CITY OF ALBUQUERQUE

**RE: Lot 6-A Block 12 Unit 5 Volcano Cliffs SAD 227
6520 Jade Dr NW
Grading and Drainage Plan
Engineers Stamp Date 8/17/17 (D10D032)**

Based upon the information provided in your submittal received 8/30/17, this plan cannot be approved for Grading Permit until the following comments are addressed.

CITY OF ALBUQUERQUE
MUNICIPAL DEVELOPMENT DEPARTMENT
ENGINEERING DEVELOPMENT DIVISION
1620 JADE DRIVE NW
GRADING & DRAINAGE PLAN

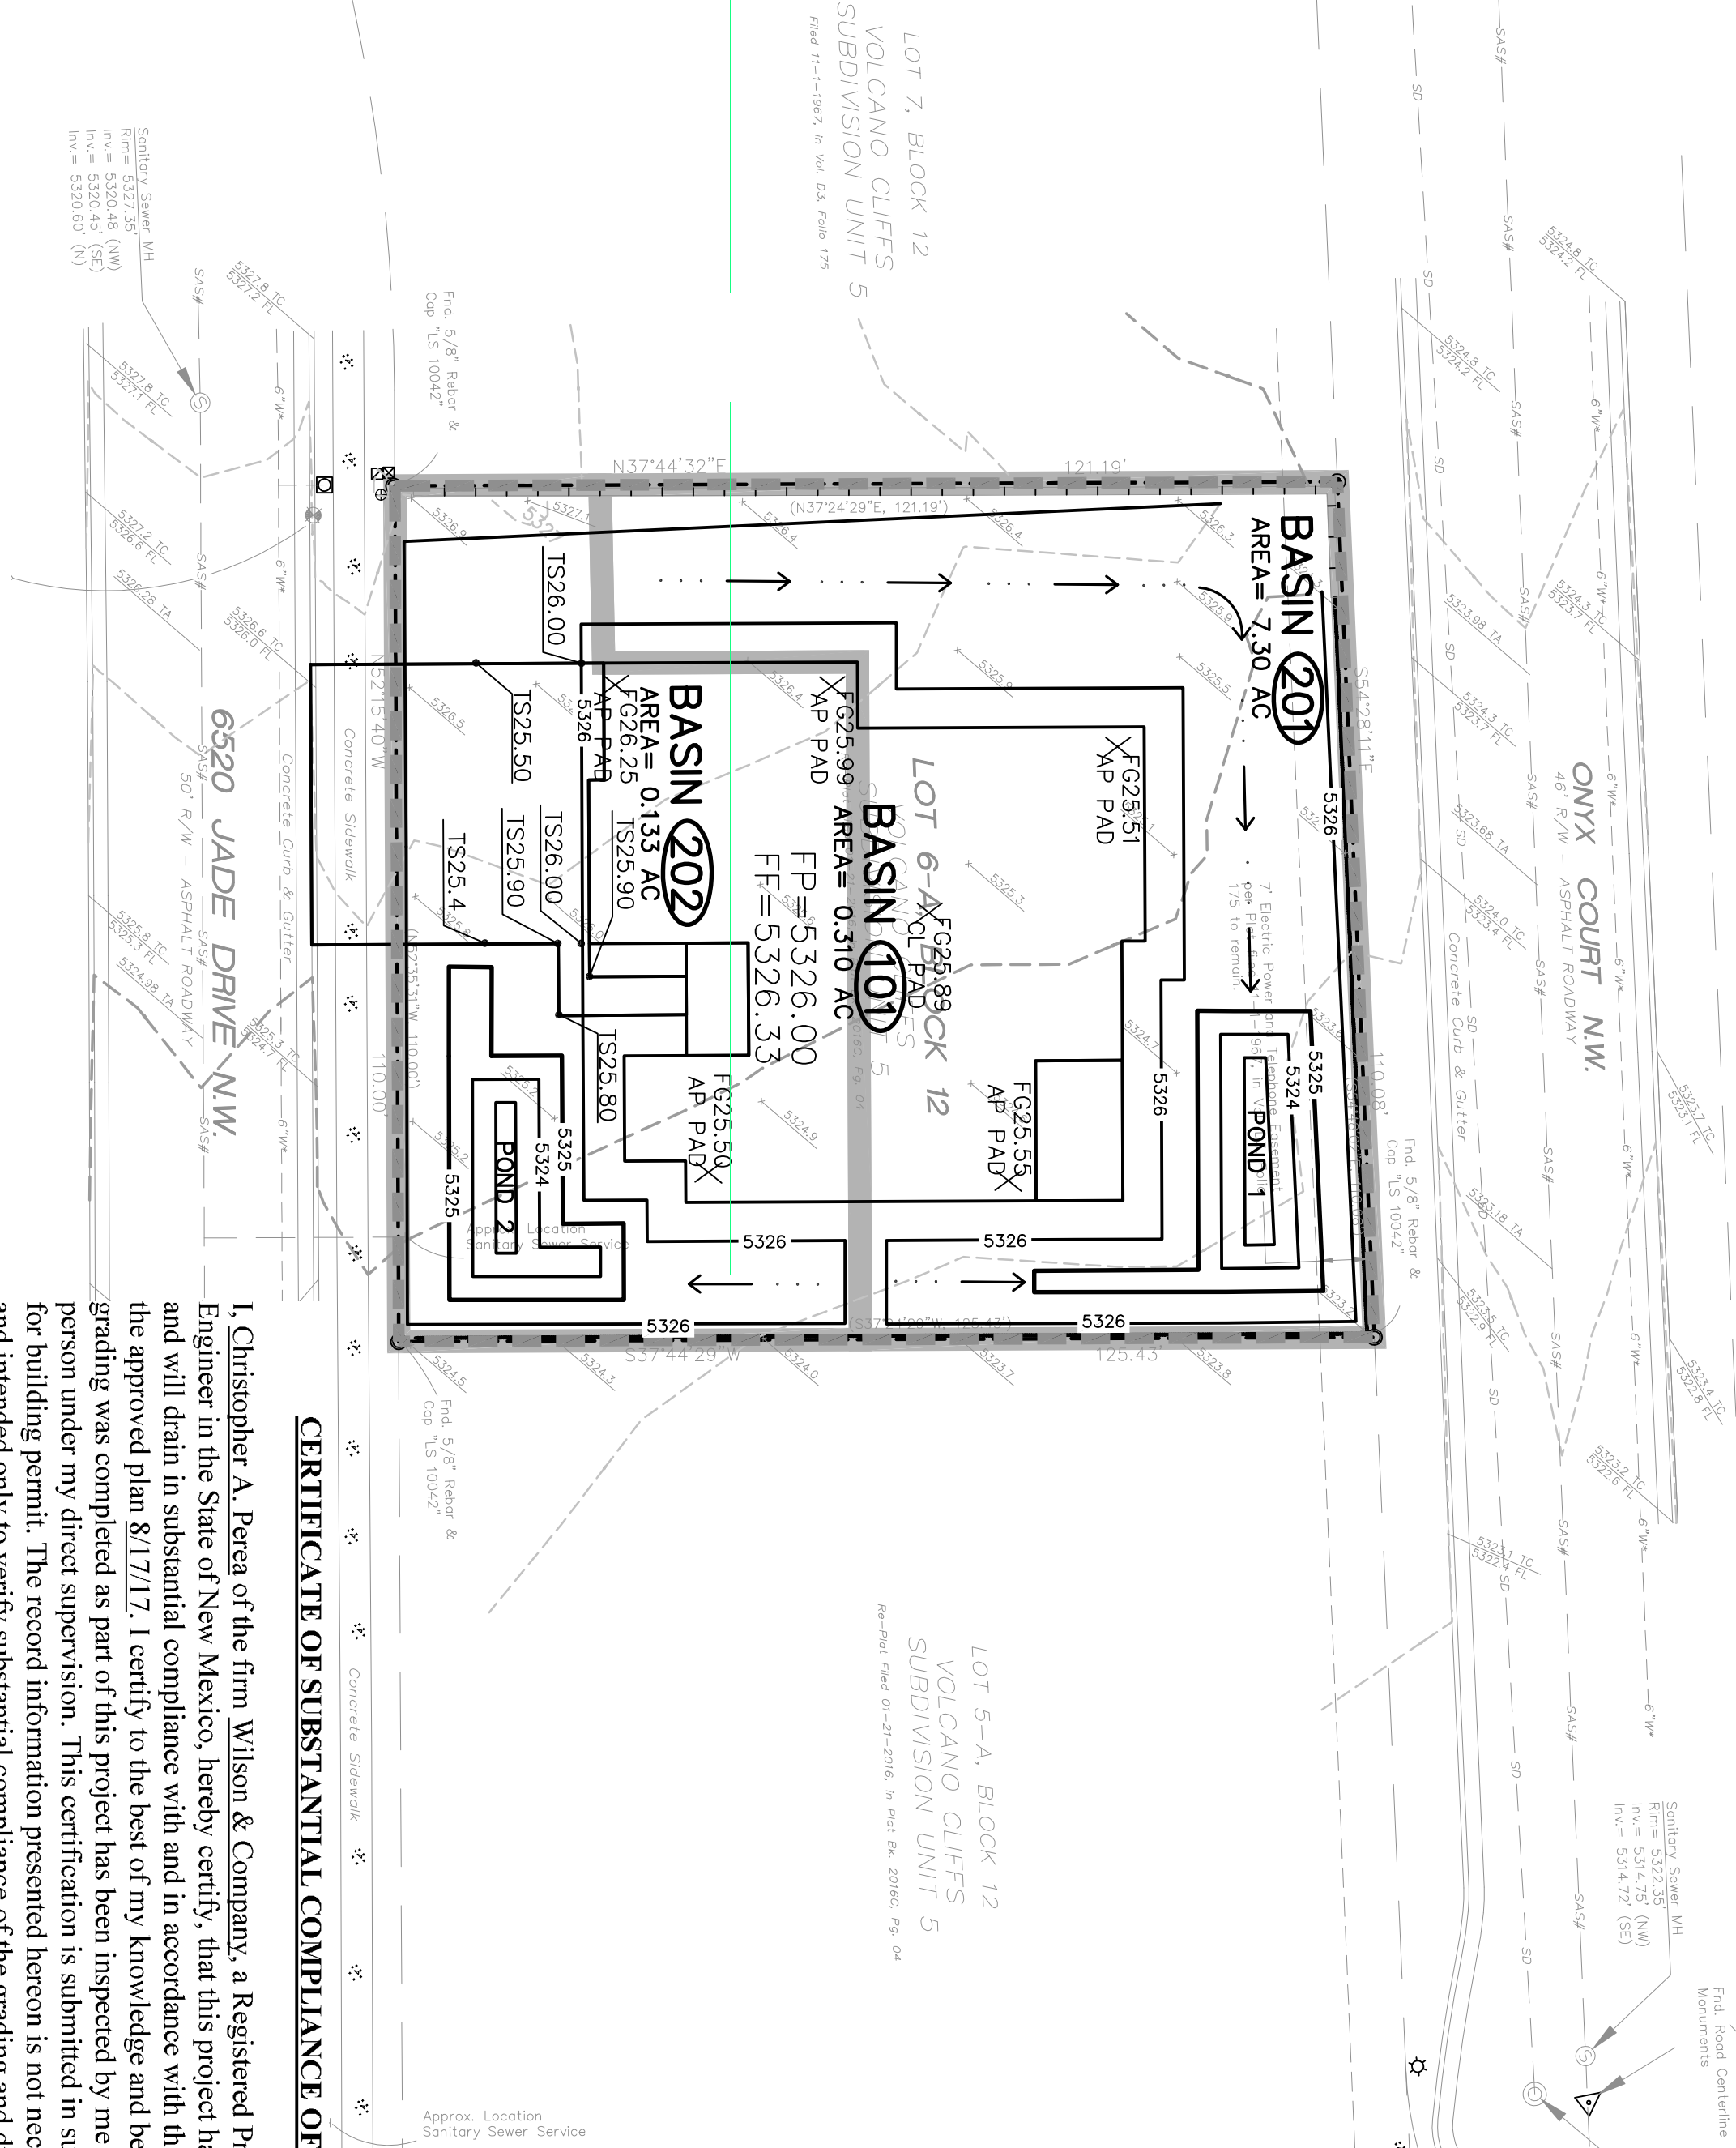
- Provide elevations in and around the site.
- Provide street elevations.
- A pad was not visible at the time of my field inspection.

If you wish to leave the note of pad certification along with your signature this will be fine. However, I still need elevation points in and around the site to make sure the home will not get flooded.
